From: Amanda Scholes on behalf of Planning.Responses
Sent: 23 May 2018 10:41
To: Planning Scanning
Subject: FW: LY/3/18/HH and LY/4/18/L - Replacement Gates, Lyminster House, Church Lane

“ While there is no objection in principle to the replacement of the gates, including an automation system, it is recommended that the profile of the replacement gate be either: horizontal to top edge, giving a more traditional profile OR downsweeping OR be metal gates. There is a concern that the new steel posts to support the proposed gates would be visually intrusive, and it is preferable that these be set to brick piers (concealing electrical works/mechanisms etc). Other than this, a manual gate could be fitted. I would currently recommend the proposed gates be refused.”

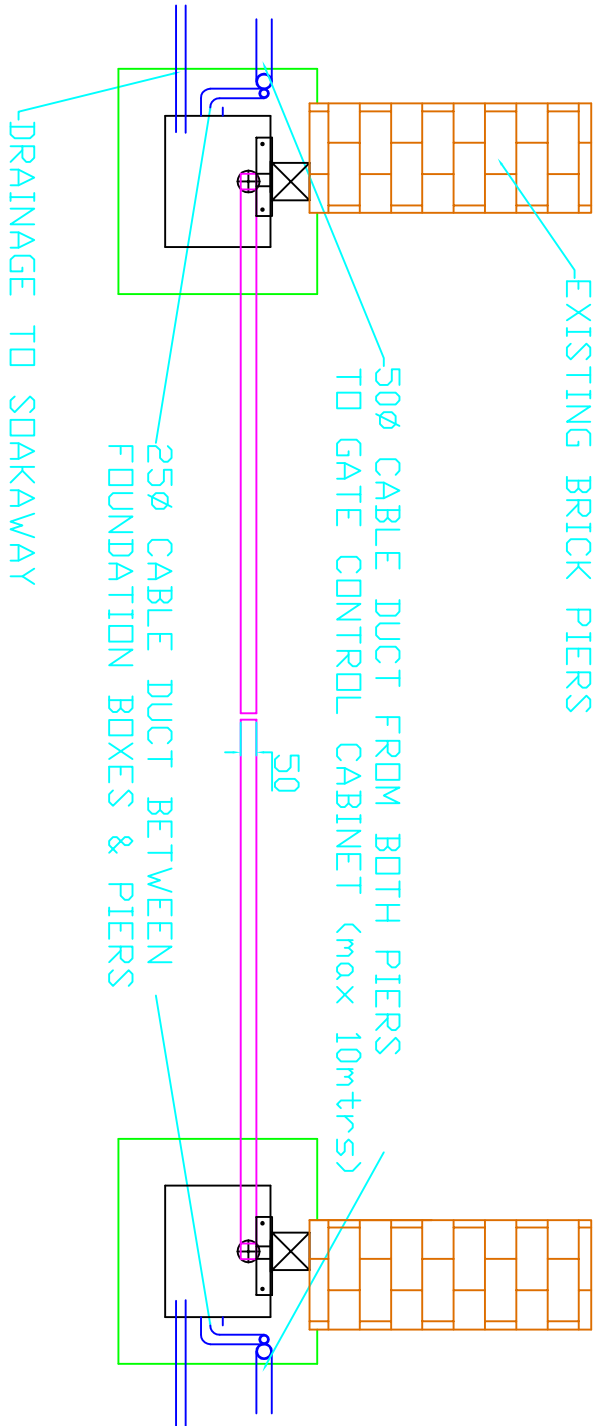
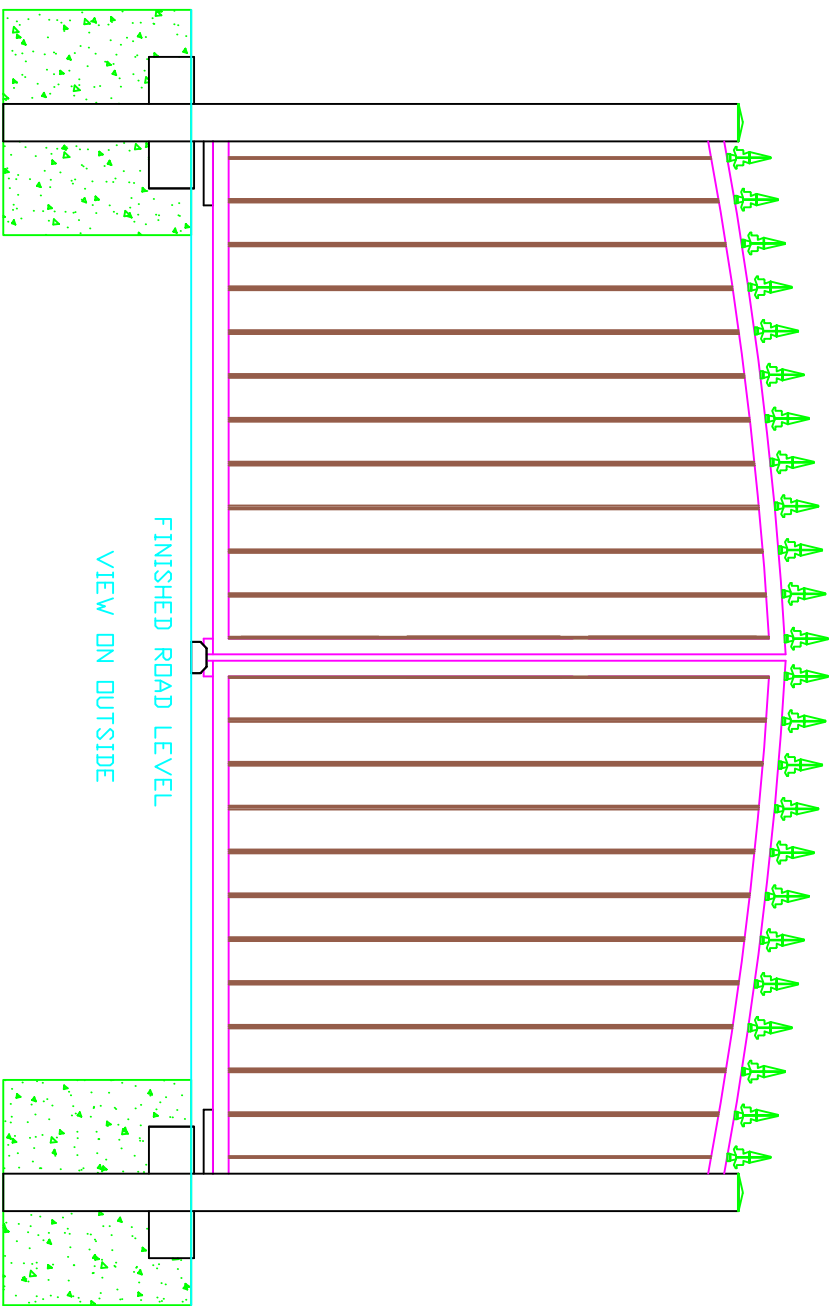
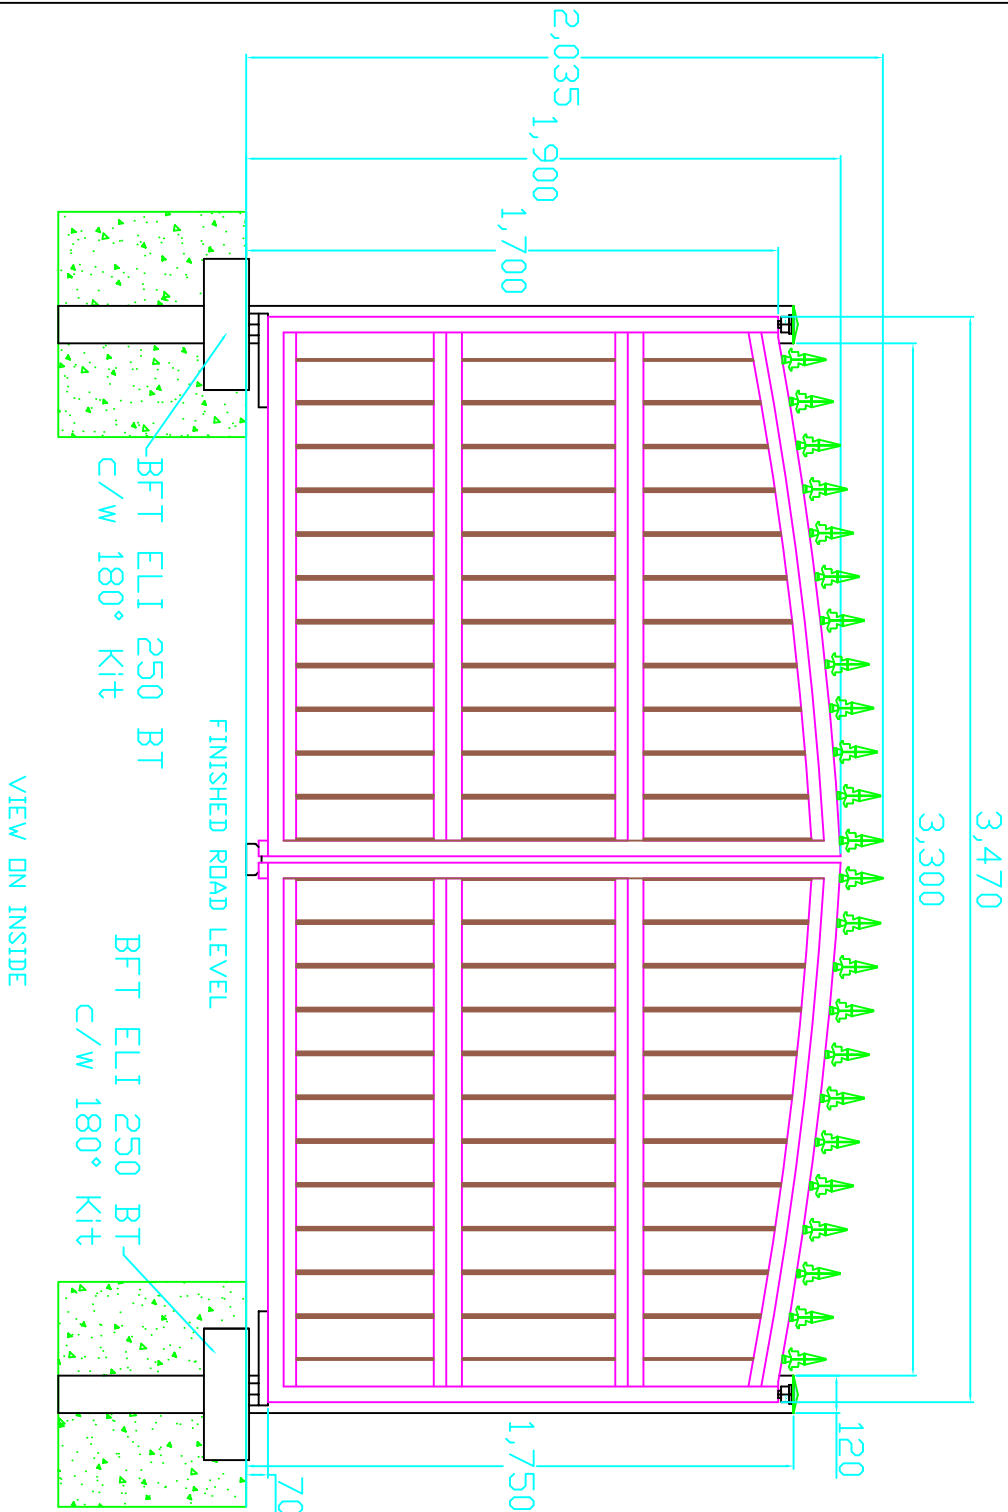
I would therefore appreciate that consideration is given to modifying the design of the gates accordingly. To allow time for receipt of amended details I would be grateful to your agreement to an extension of time on the applications until 24-05-2018, by return.

1. Pair of Close Boarded Wooden Vehicle Gates with Steel Frame and Sapele infill to Suit Opening of 3220mm wide by 1900mm high
2. Frame and Top Spikes -Black RAL9005
3. Infill -Painted White Gloss
4. Pair of Steel Posts c/w Top Hinges. Colour RAL9005 Black

As discussed please find attached a revised drawing for the gates. You will note:

- Steel posts to the rear of the existing brick piers (as per original drawing). Please also note that at additional cost the gate mechanisms will be located underground further reducing any visual impairment in keeping with the character of the property.
- Revised horizontal design of the gates themselves as per our discussion
